## Drax Bioenergy with Carbon Capture and Storage (BECCS) Project – EN010120

### Section 51 advice regarding draft application documents submitted by Drax Power Limited

On 4 February 2022, Drax Power Limited submitted the following draft documents for review by the Planning Inspectorate as part of its Pre-application Service<sup>1</sup>:

DRAWING NUMBER
EN010120-PA-WP-2.3-Sheet0

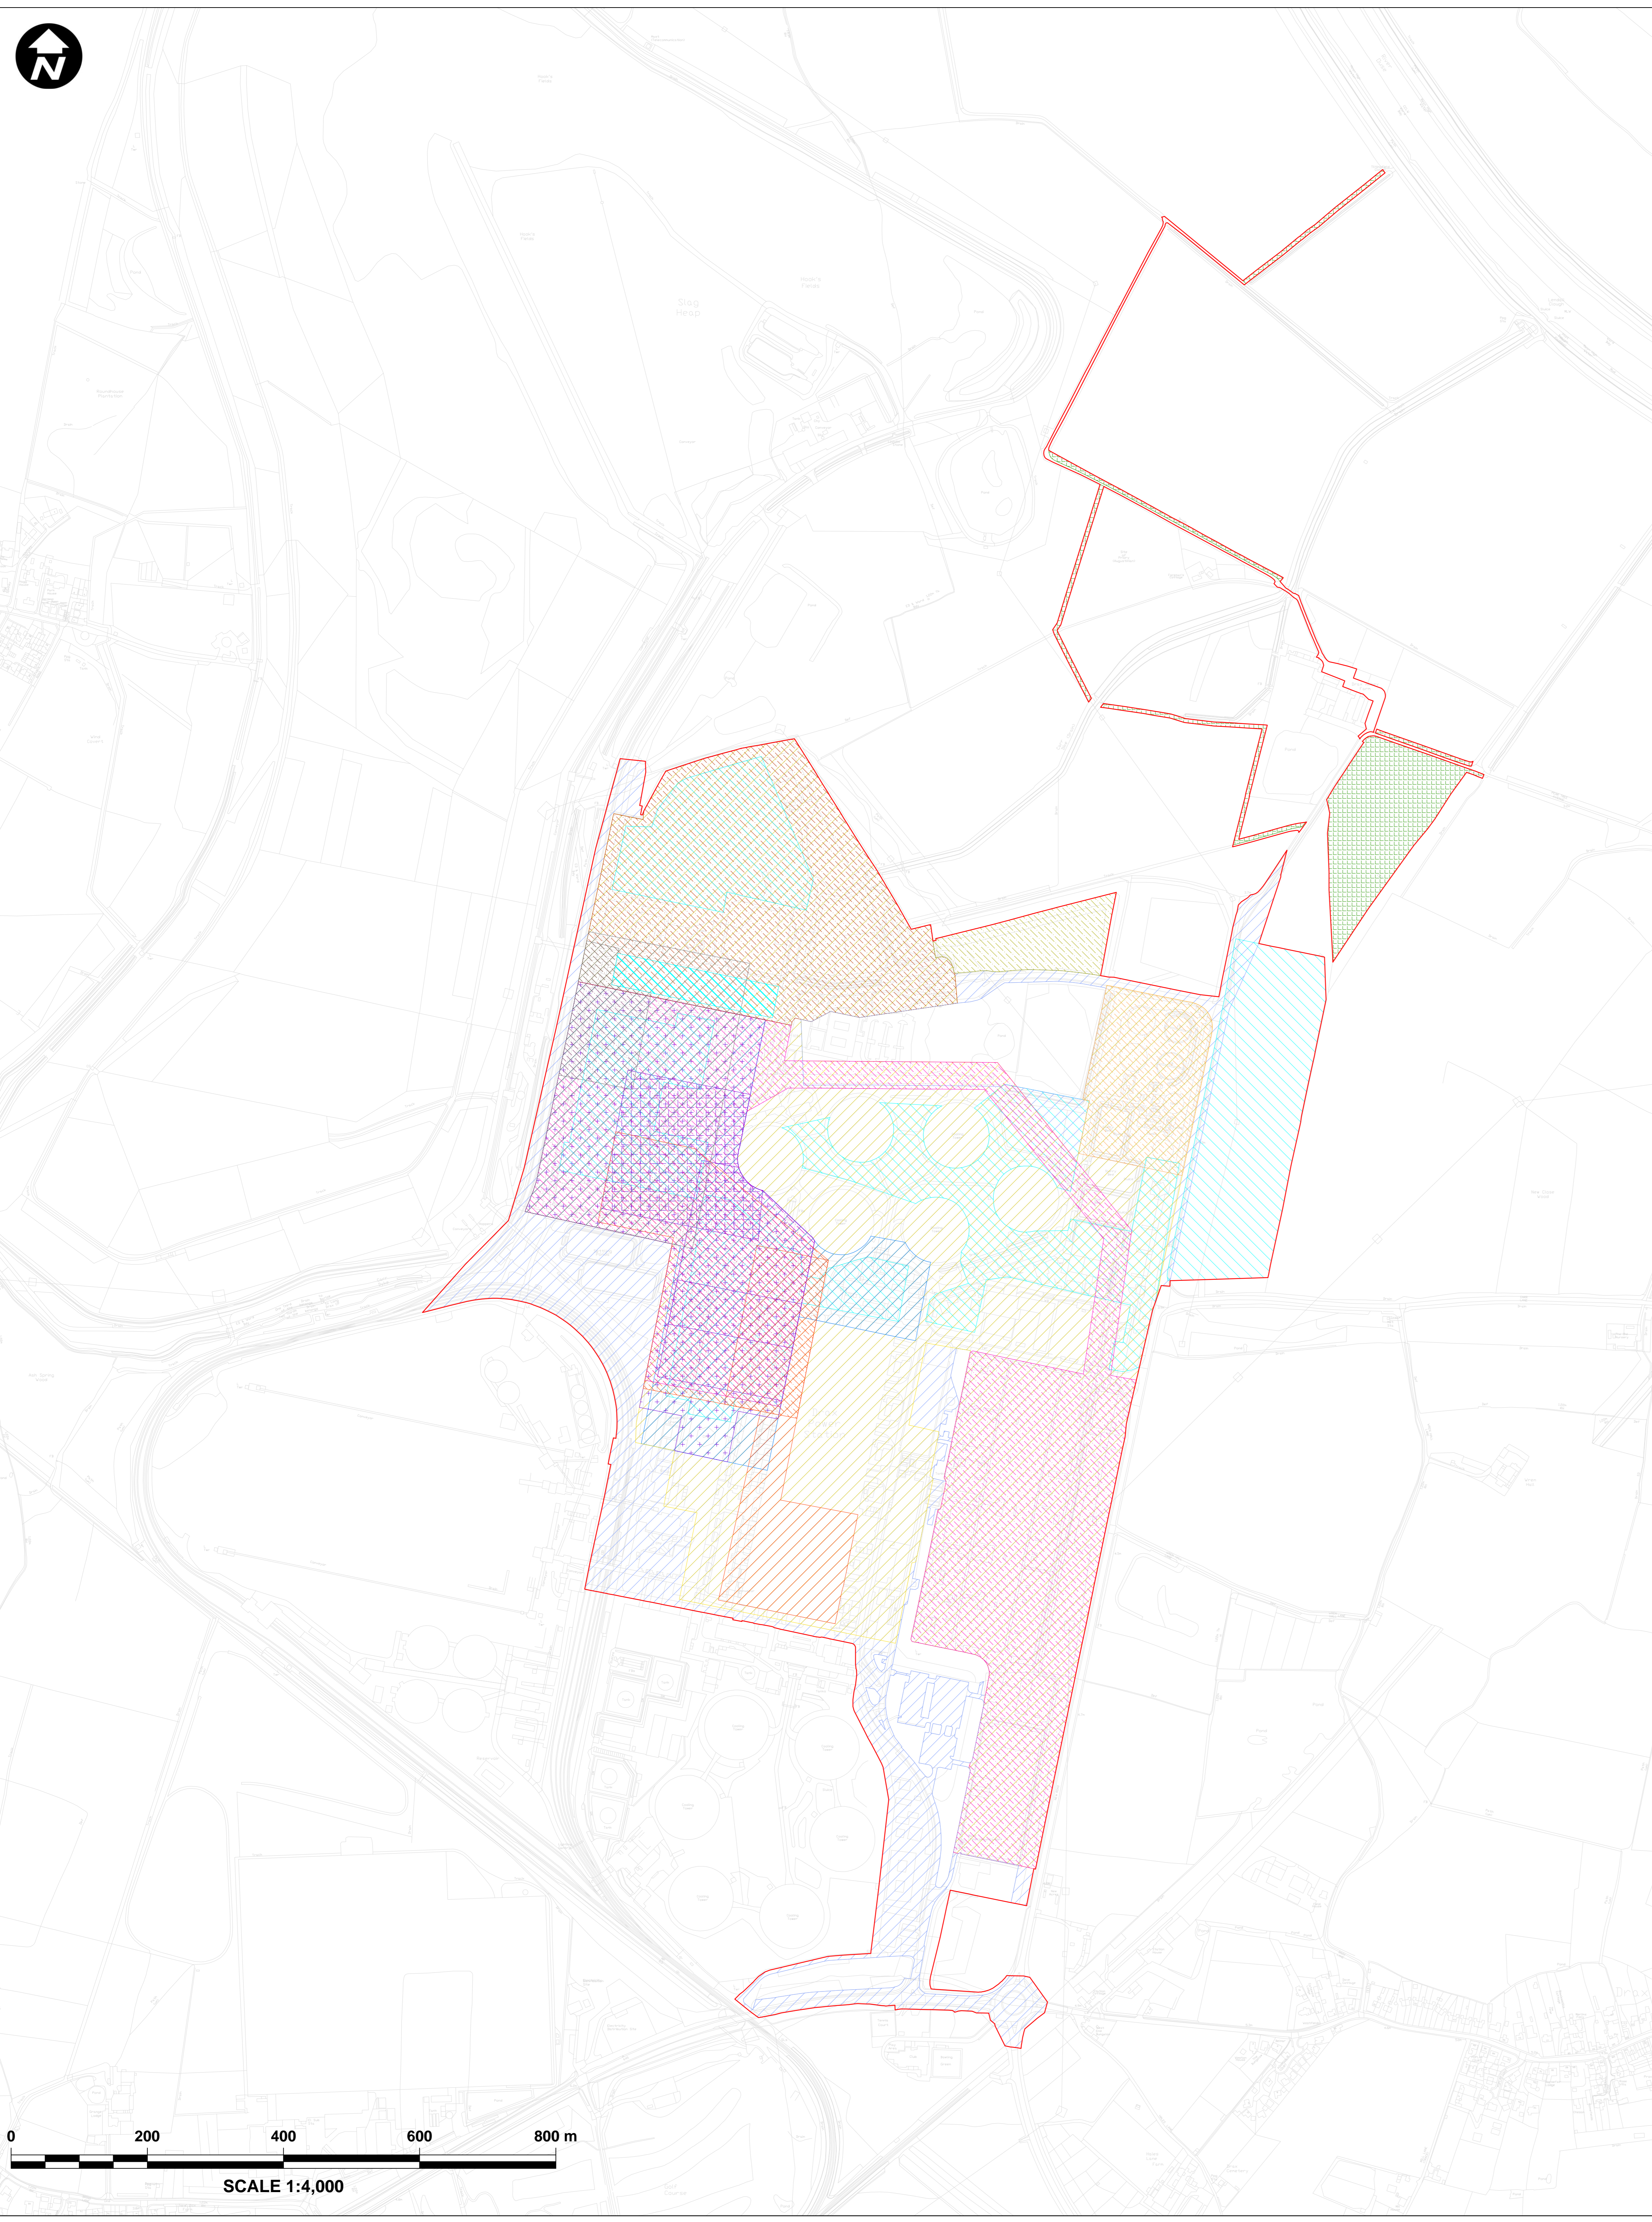
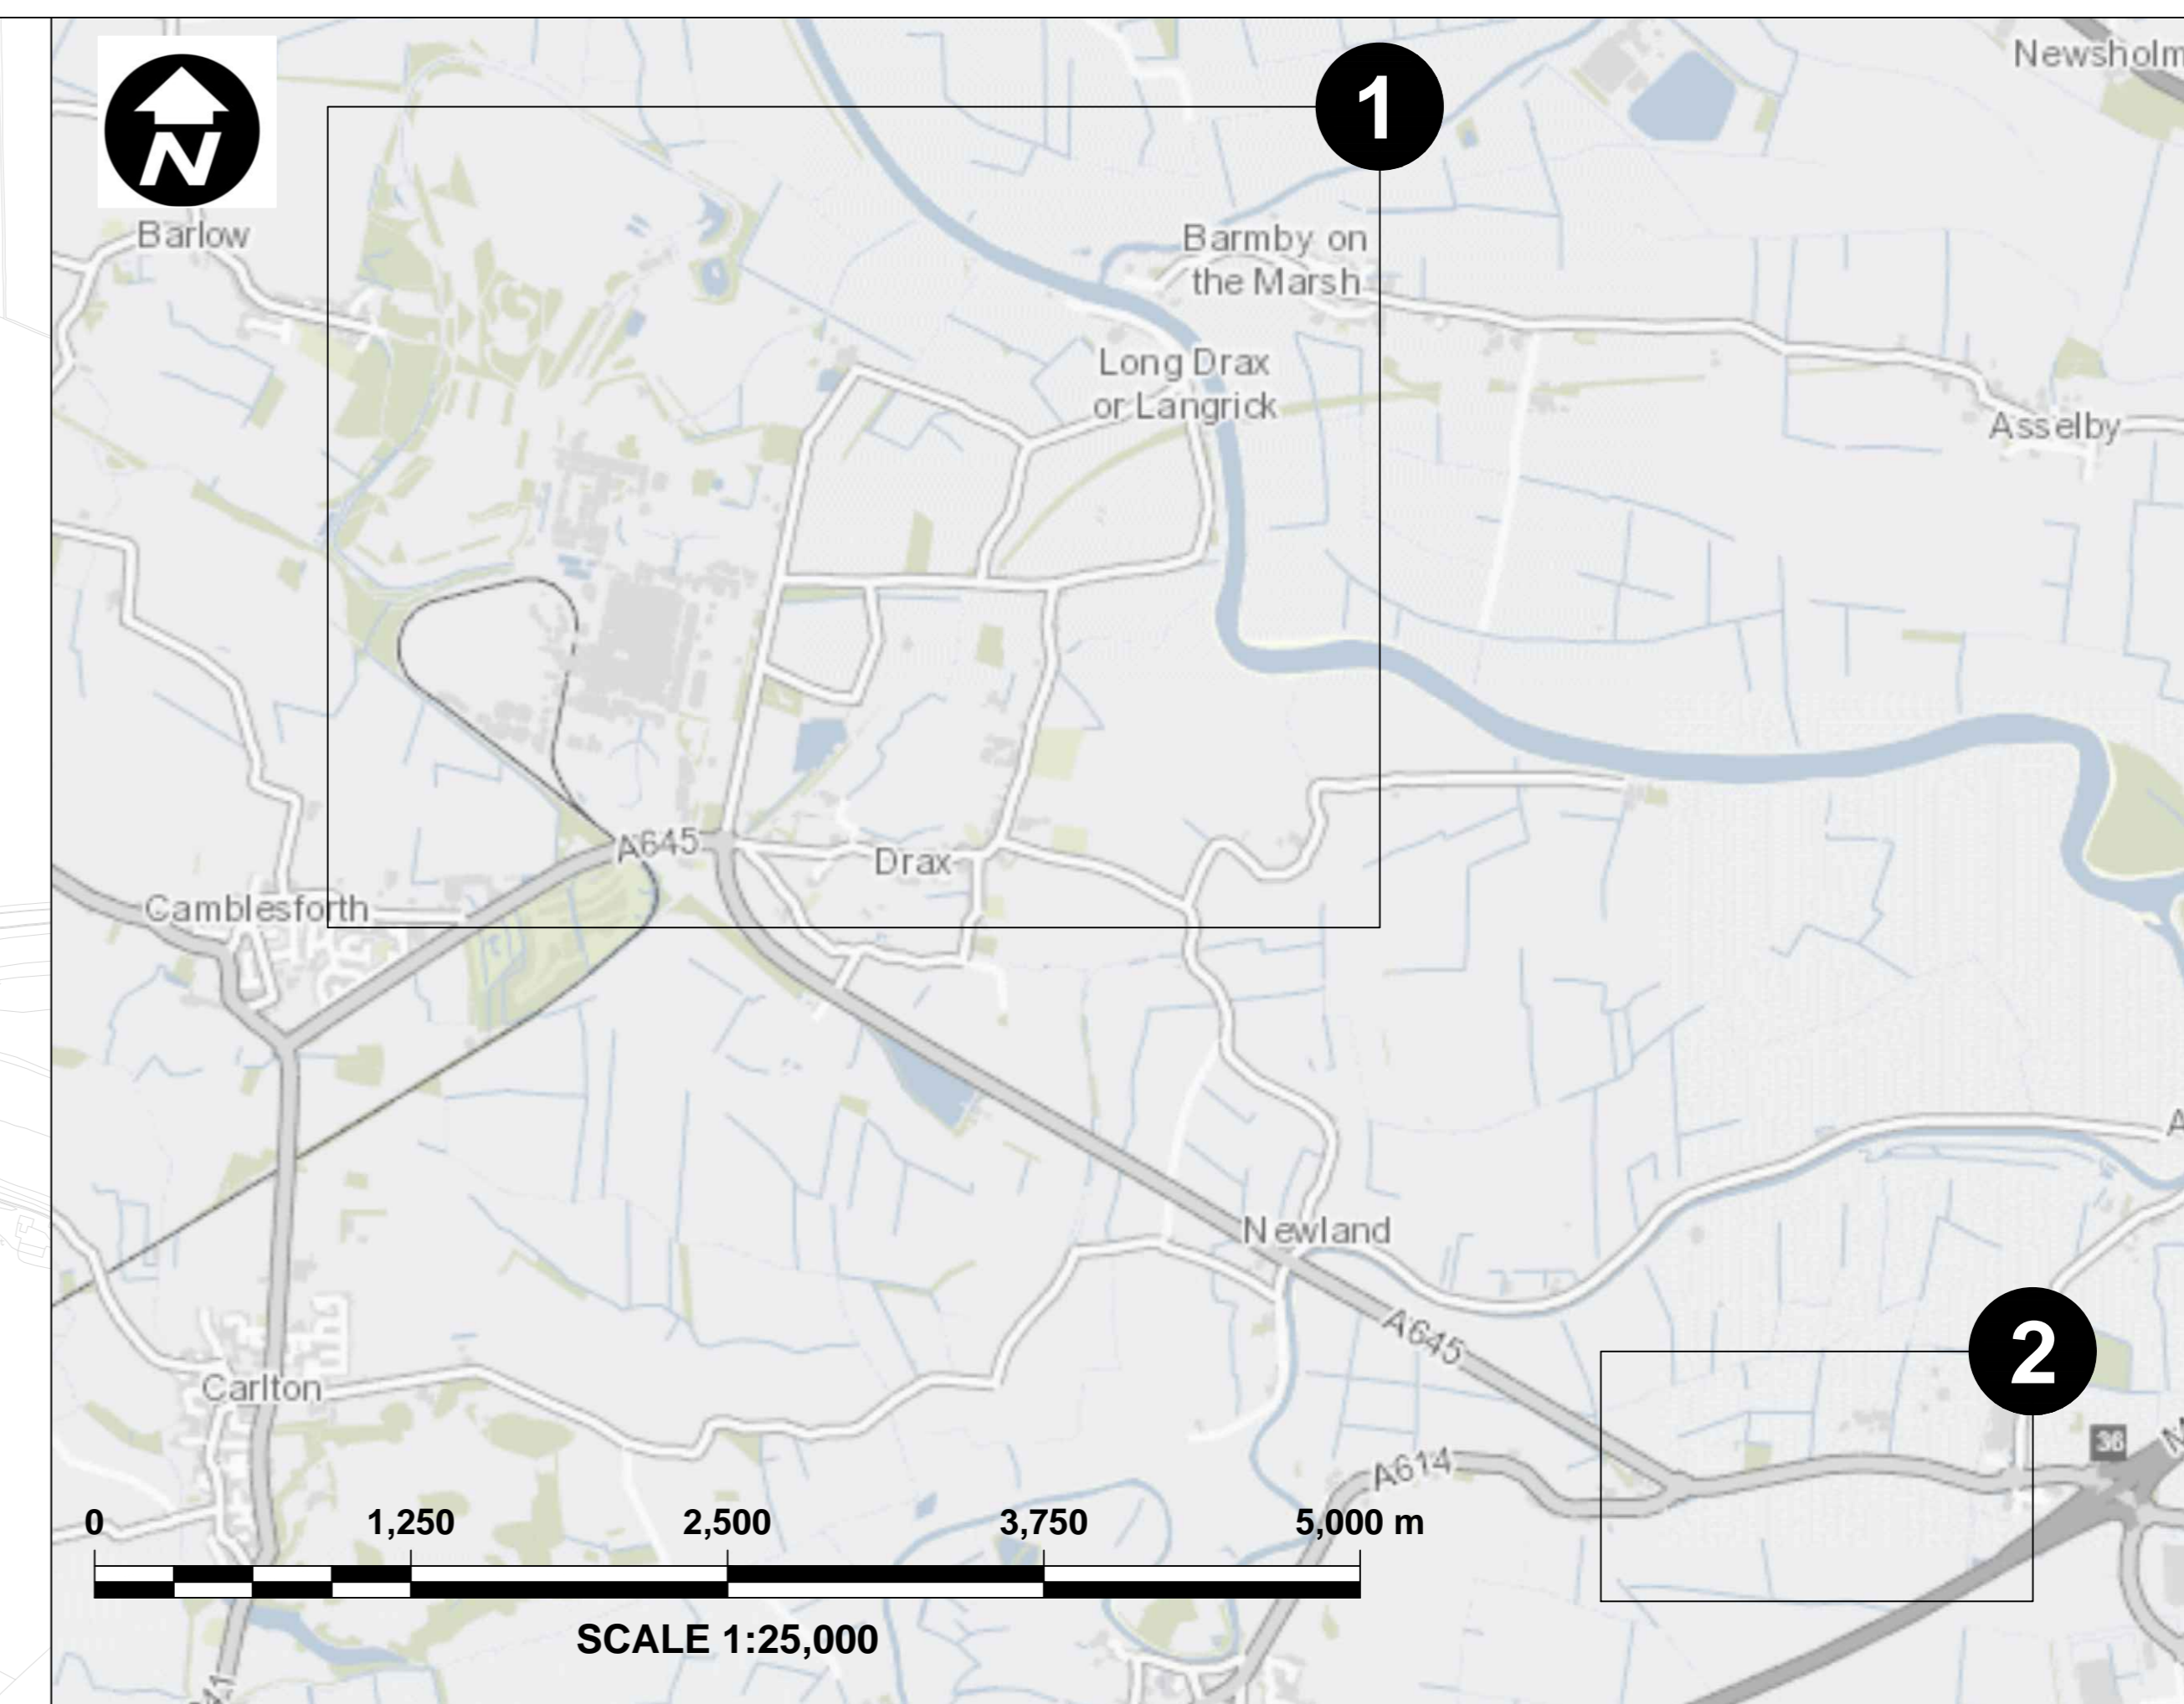
Works Plans		
Ref No.	Plan ref	Comment/Question
34.	General	The presentation of the Works Plans as a single overlay followed by each Work No. on a separate plan is very helpful in presentation terms. However, it does emphasise how broad the parameters have been drawn for each Work No. Will these be narrowed down prior to submission of the application, during Pre-examination, Examination or Post-decision (subject to approval)?
